Town & Country Planning Act 1990 (as amended)
Town and Country Planning (Development Management Procedure) (England) Order 2015
Application for the discharge of conditions imposed on planning reference FG/115/17/PL relating to
5 (transport statement), 6 & 8 (Landscaping) & 10 & 11 (Materials) & 12 (fencing, bins)
44 Ferringham Lane Ferring,,

Arun District Council have decided to **REFUSE** details reserved by condition for the **following reasons:**

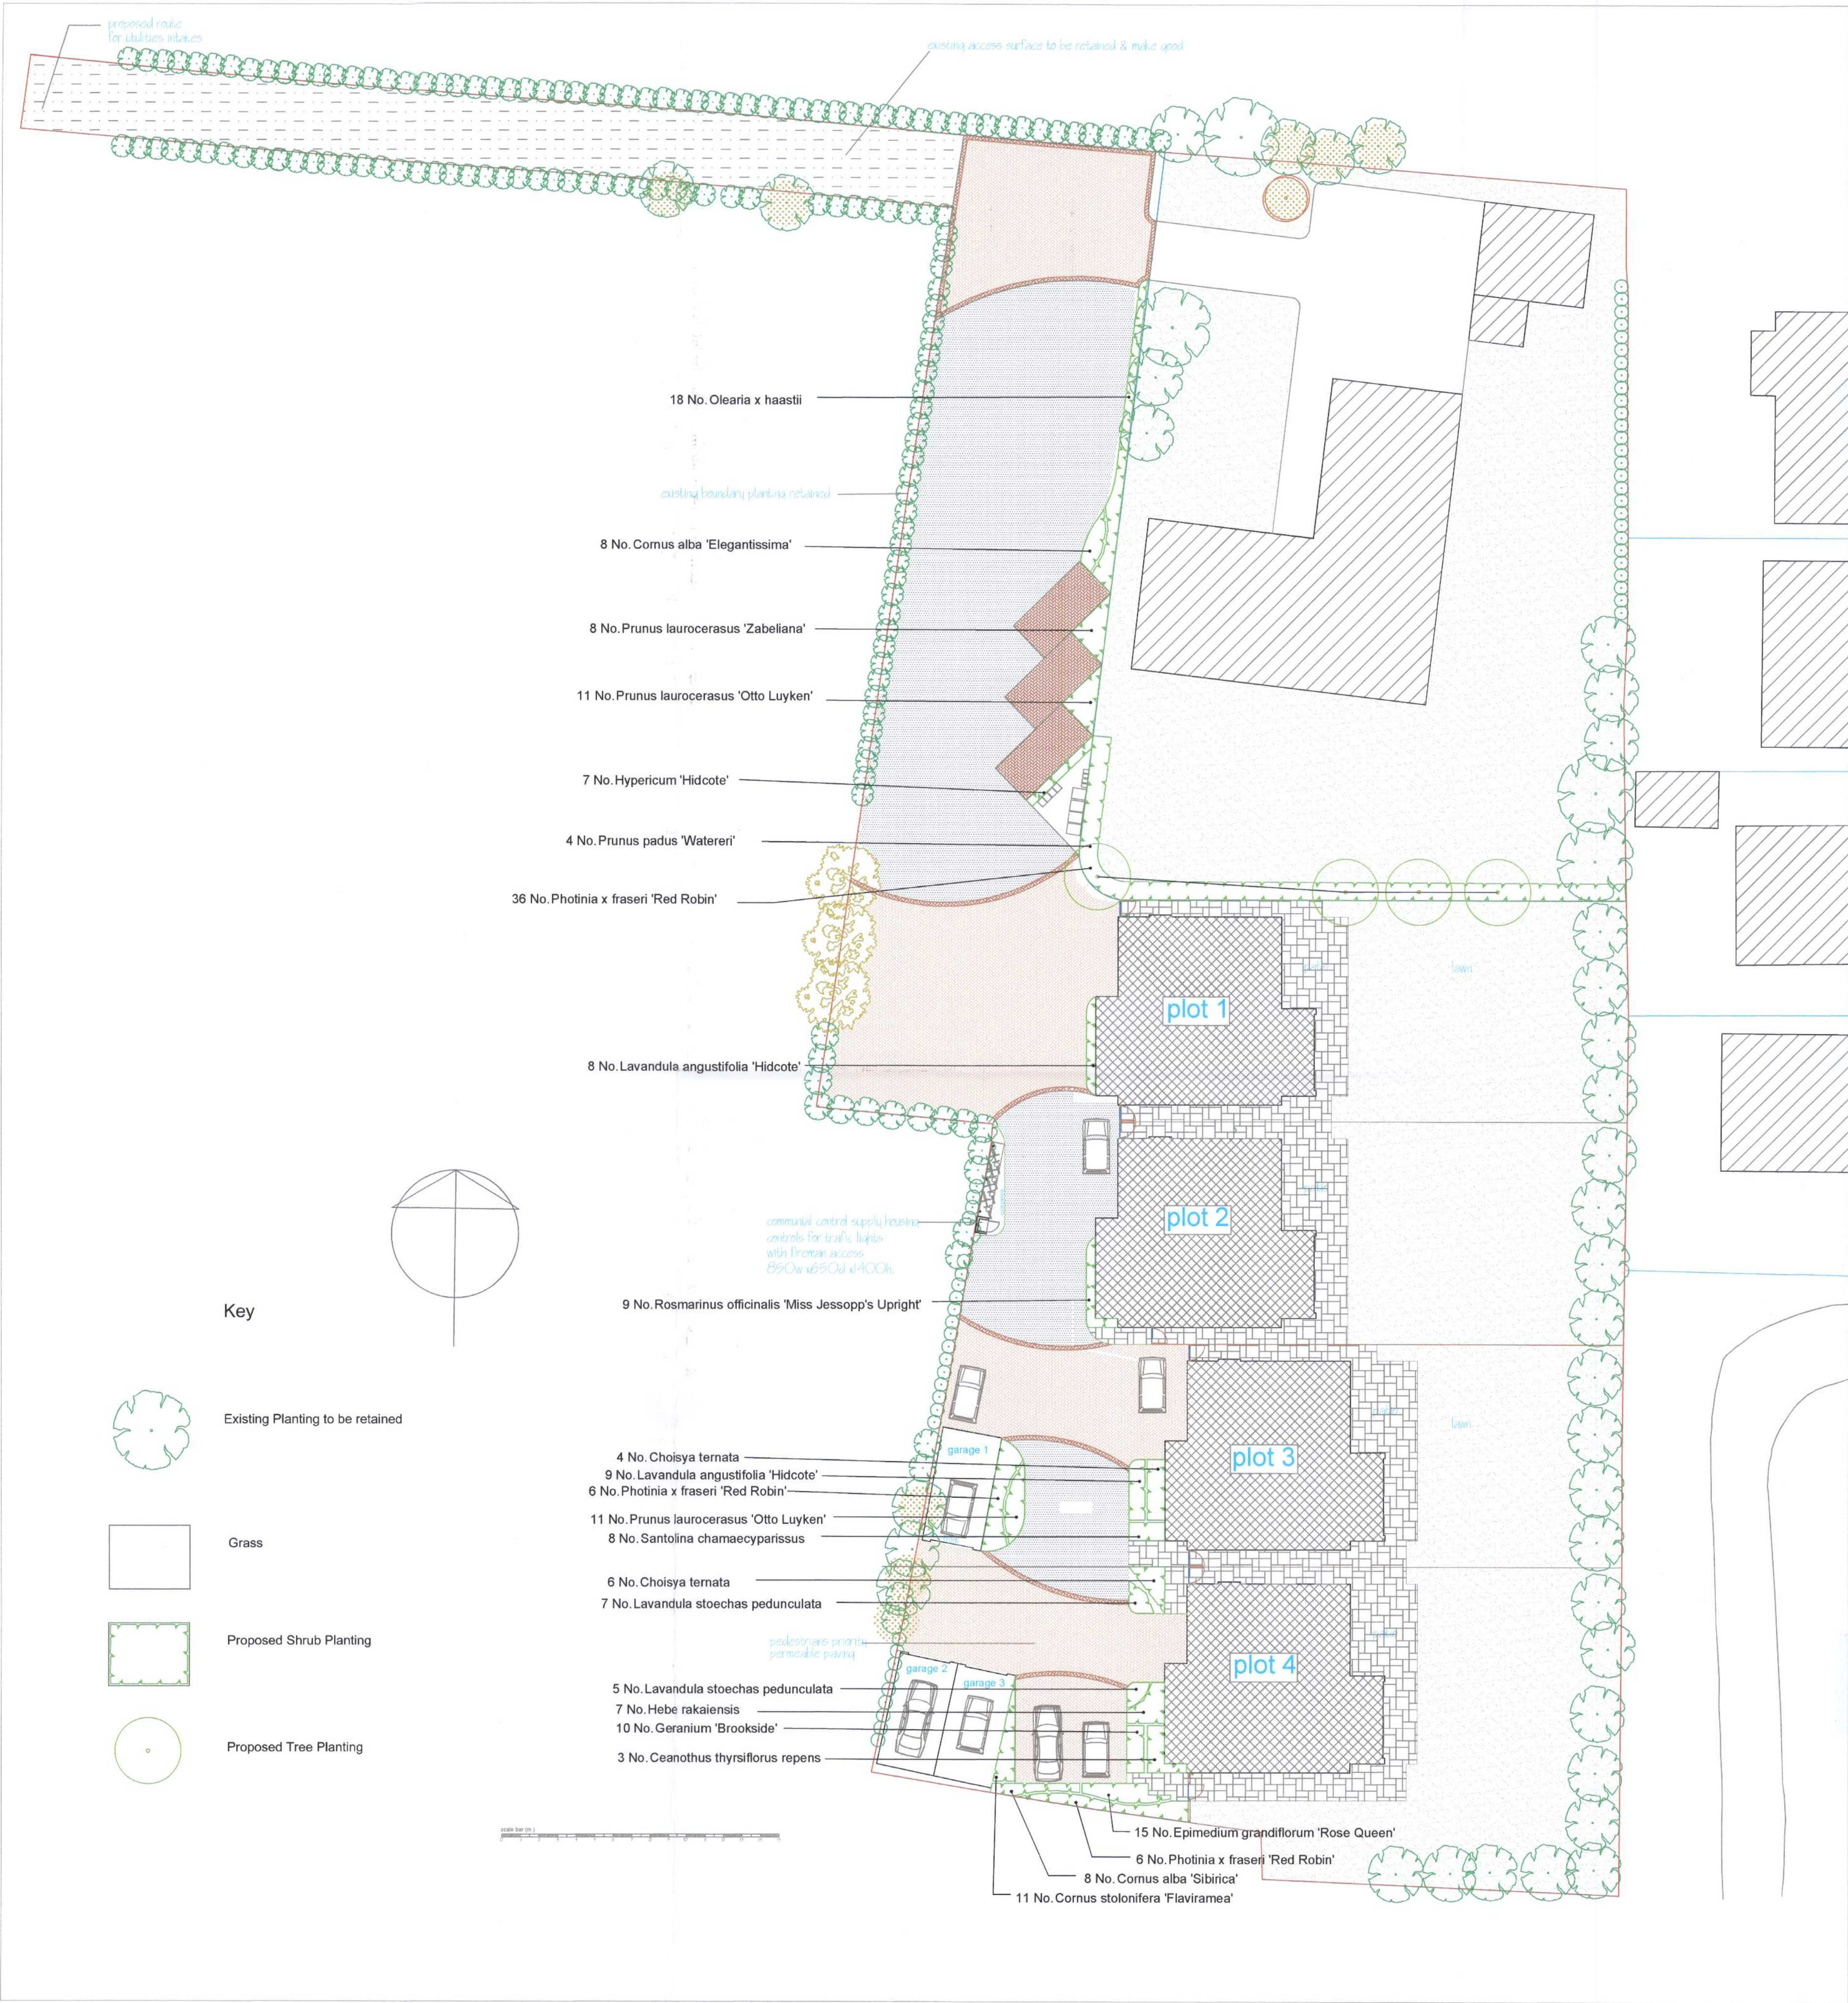
This condition cannot be discharged given the lack of any details relating to the method of tree and shrub protection/retention during the course of development and the limited number of trees it is proposed to plant.
